CAWSTON PARISH COUNCIL COMMENTS OS SUBMISSIONS FOR DEADLINES 6 TO 9, NORFOLK BOREAS OFFSHORE WINDFARM , DEADLINE 10.

Cawston PC wishes to submit the following for Deadline 10. These are responses to key points noted in other submissions from Deadlines 6 to 9.

Highway Intervention Scheme

www.createconsultingengineers.co.uk

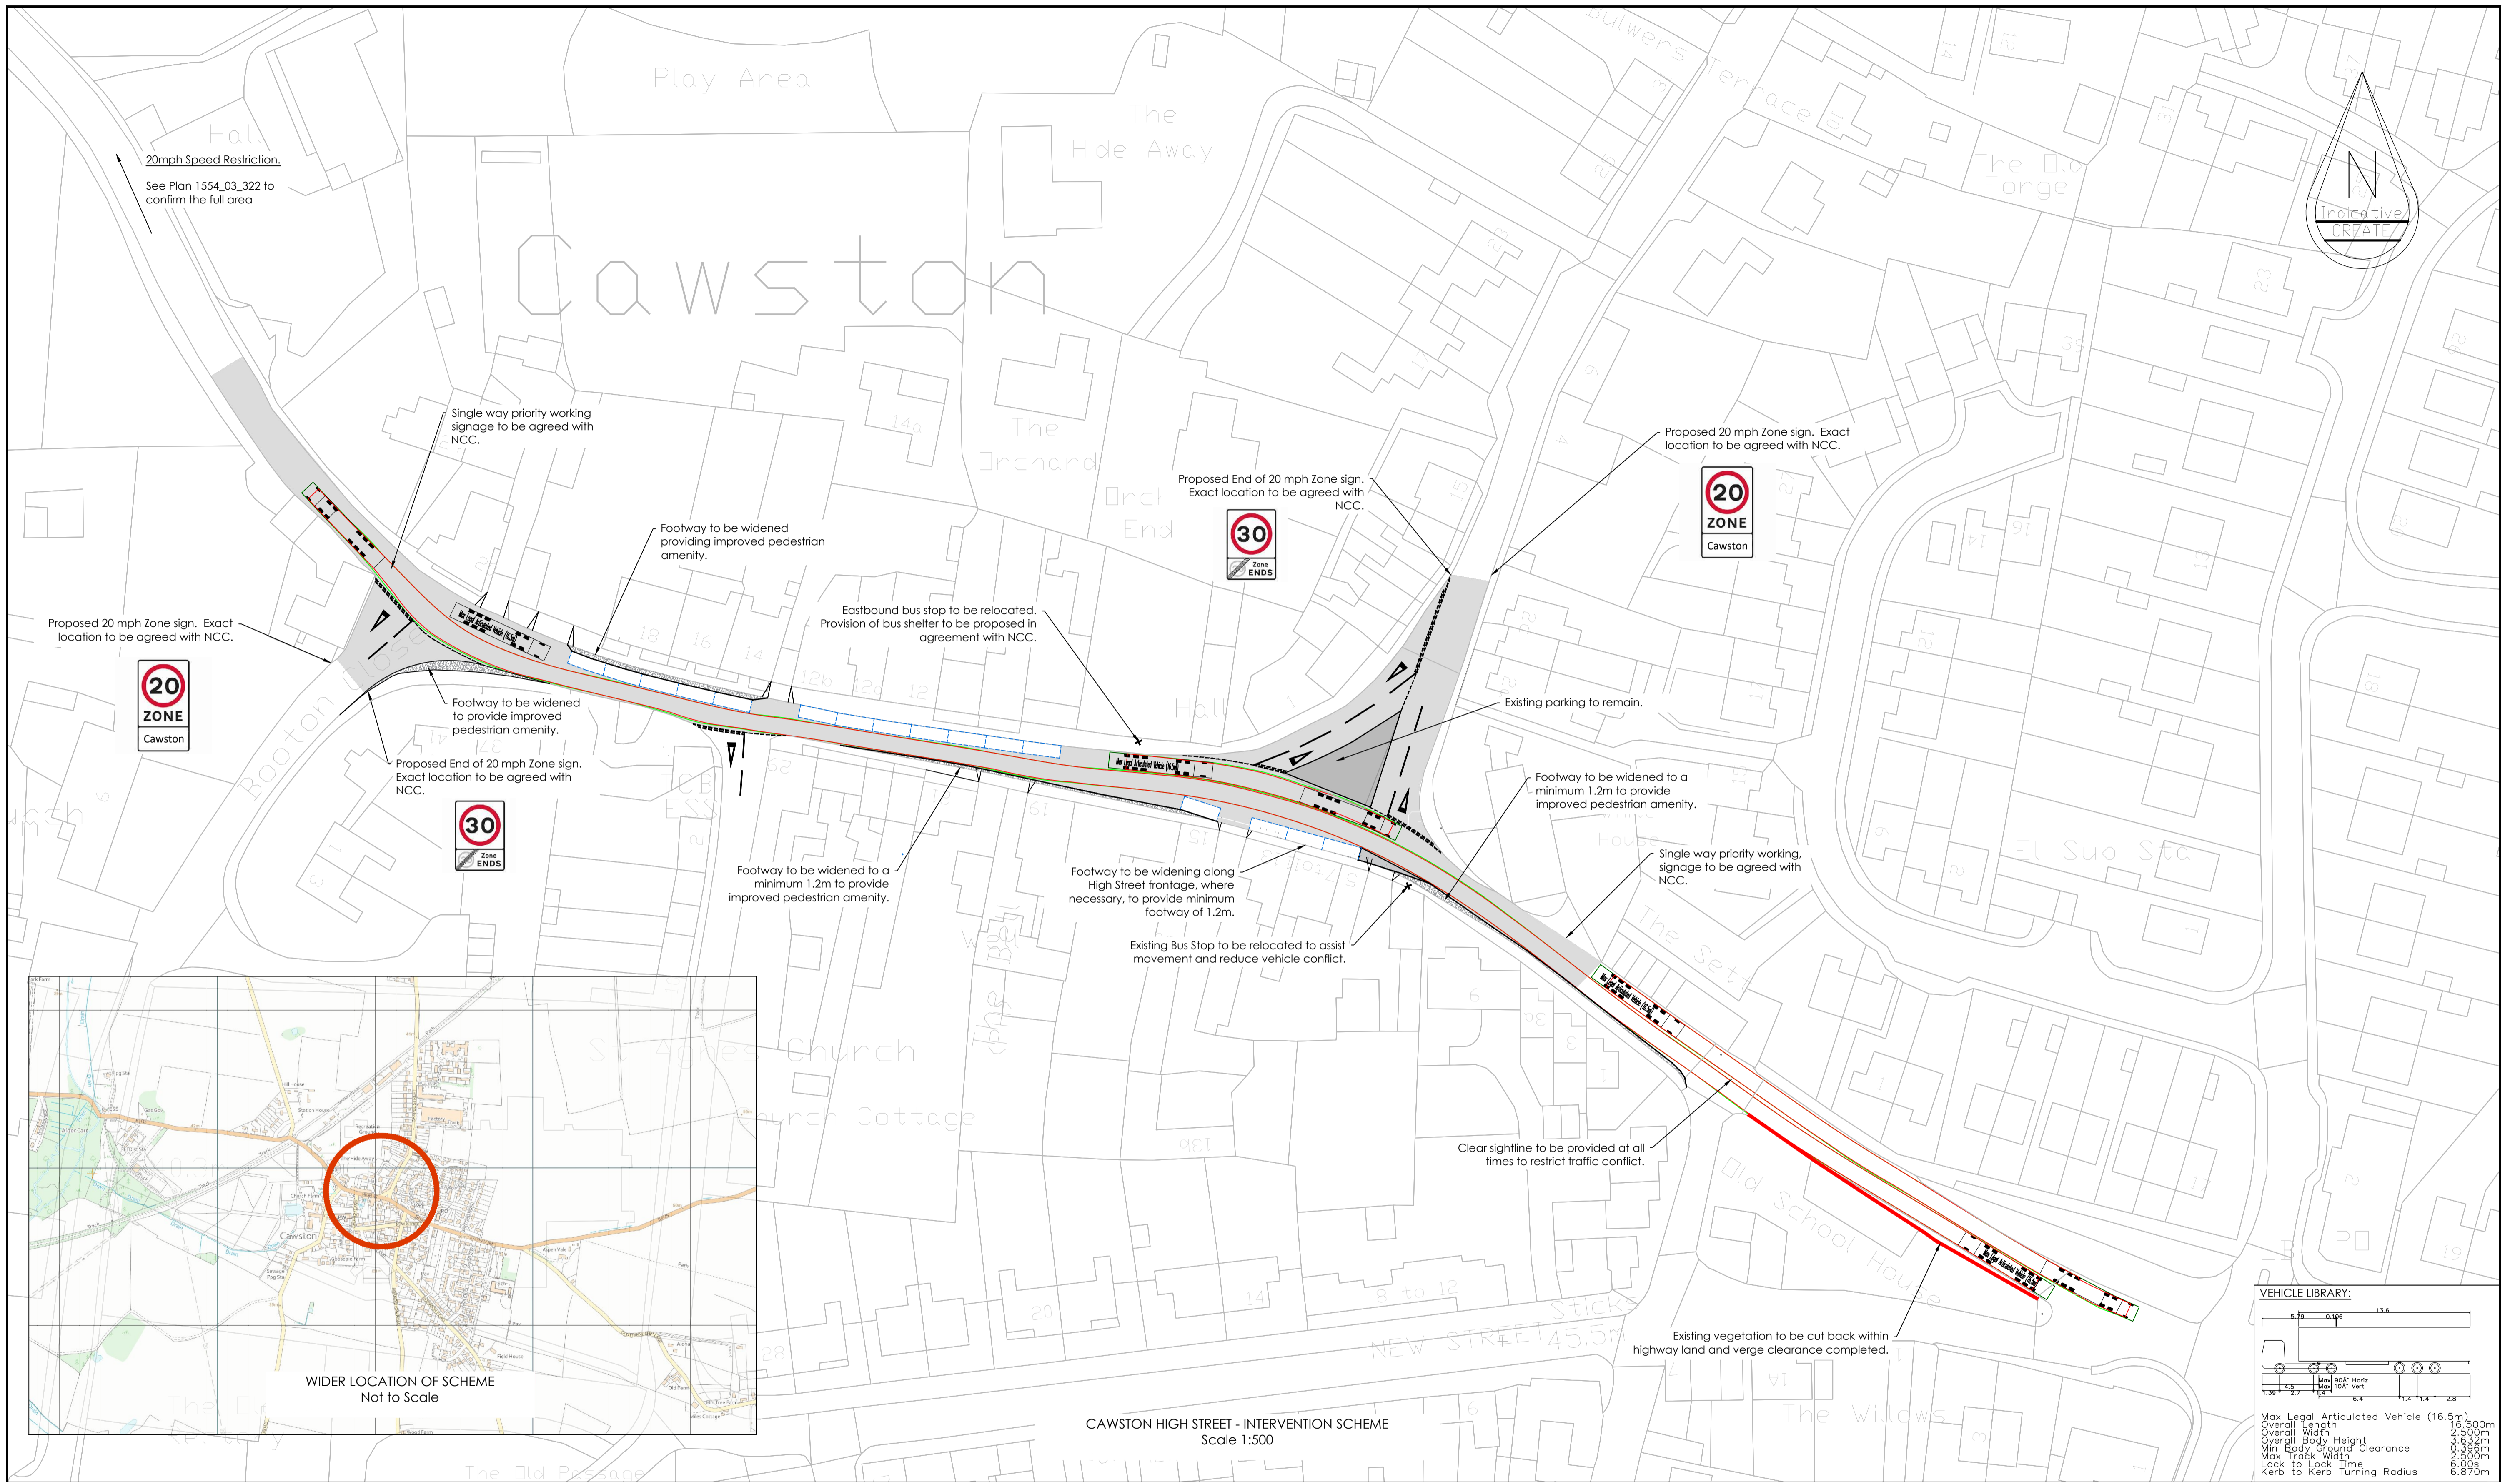
The Applicant supplies further drawings which purport to show how HGVs and other vehicles should be able to pass each other. These drawings show that in many parts of the village the tracks of vehicles pass so close as to be indistinguishable at the screen resolutions available to Cawston Parish Council, demonstrating that in much of the village HGVs are unable to pass safely.

The additional width of vehicles from wing mirrors is not shown in the drawings and even in the areas designated for passing the additional width for two sets of wing mirrors and a safe passing distance between them is not evident.

1. The ability of all HGV drivers to be able to see oncoming traffic around corners on the bend at the railway bridge, on the bend by the Old Forge and on the bend close to White House Farm
2. A requirement for all HGVs, not only the Applicant's and/or Hornsea 3 project HGVs, to arrive at evenly spaced intervals
3. Where two HGVs approach from either East or West they must not have any other road traffic between so they can fit in the proposed system of "passing places". Any train of vehicles longer than the planned "passing space", which is designed for two HGV lengths, will obstruct passing manoeuvres and make gridlock more likely.
